REF: AS12069.210310.L1.1

16 March 2021

**AS12069 WROXTON MOTO X TRACK****Noise Impact Assessment Review**

The 'Noise Impact Assessment' submitted with an application to Cherwell District Council for Wroxton Motocross Track, Banbury, has been referred to us at Clarke Saunders Acoustics for technical review.

Figure 4.1 – Noise monitoring positions

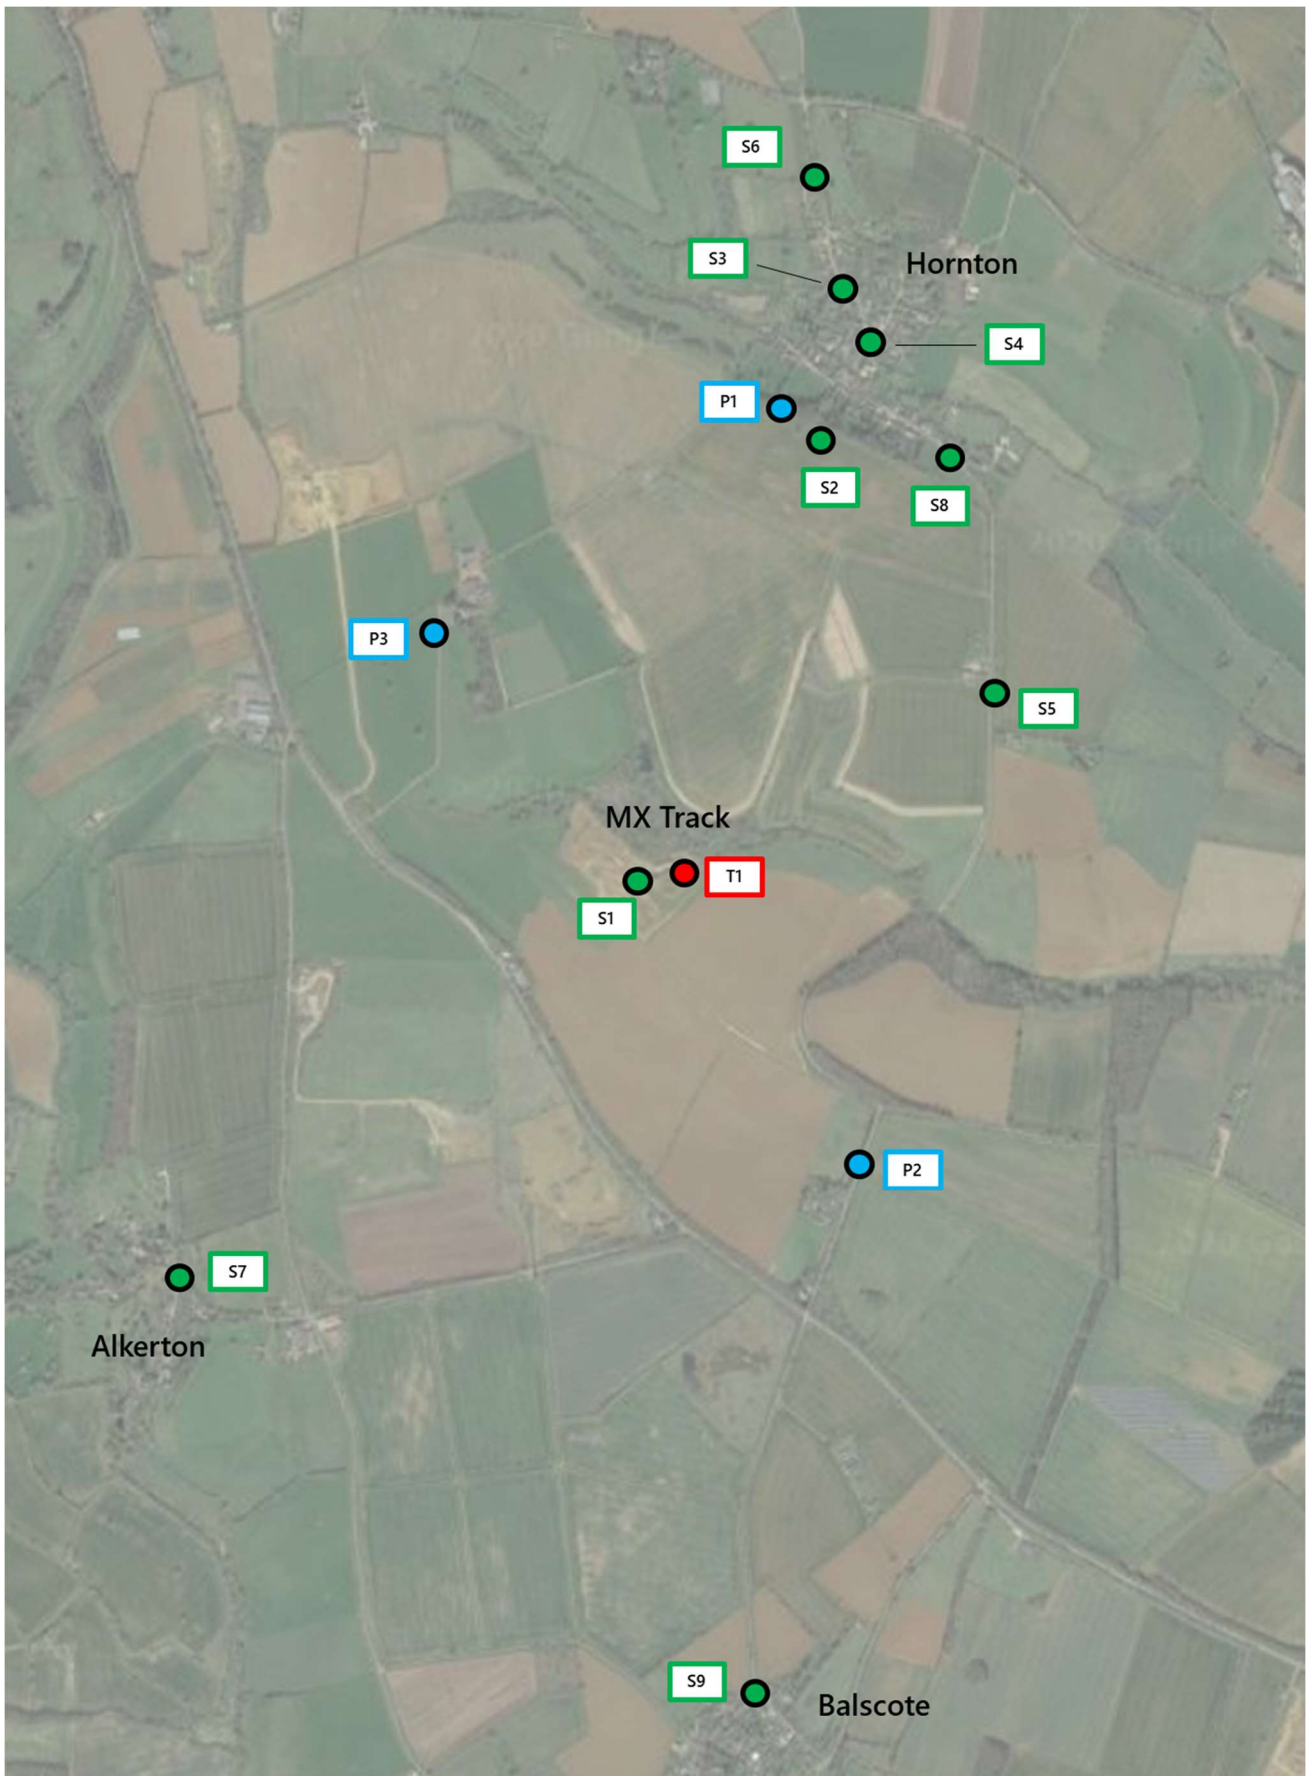
In summary, the PJA report provides some time limited measurements of noise levels in various pre-determined locations around the site. Importantly, the measurements are associated with practice activity at the track during a single visit to site. It is the type of preliminary exercise that might be useful in establishing some broad context and refining the details of more comprehensive measurements required to provide a meaningful assessment.

One of the most striking omissions is that an environmental noise survey was not undertaken beyond attendance at the practice event to establish otherwise prevailing conditions. Trends in noise variations without the activity present to determine the prevailing background noise levels at noise sensitive receptors would have allowed a fuller discussion on the ambient noise level and the general soundscape of the area. As is often the case in relatively rural settings, even at the lower windspeeds characteristic of benign calm conditions, background noise levels (measured over consecutive periods) show considerable variation.
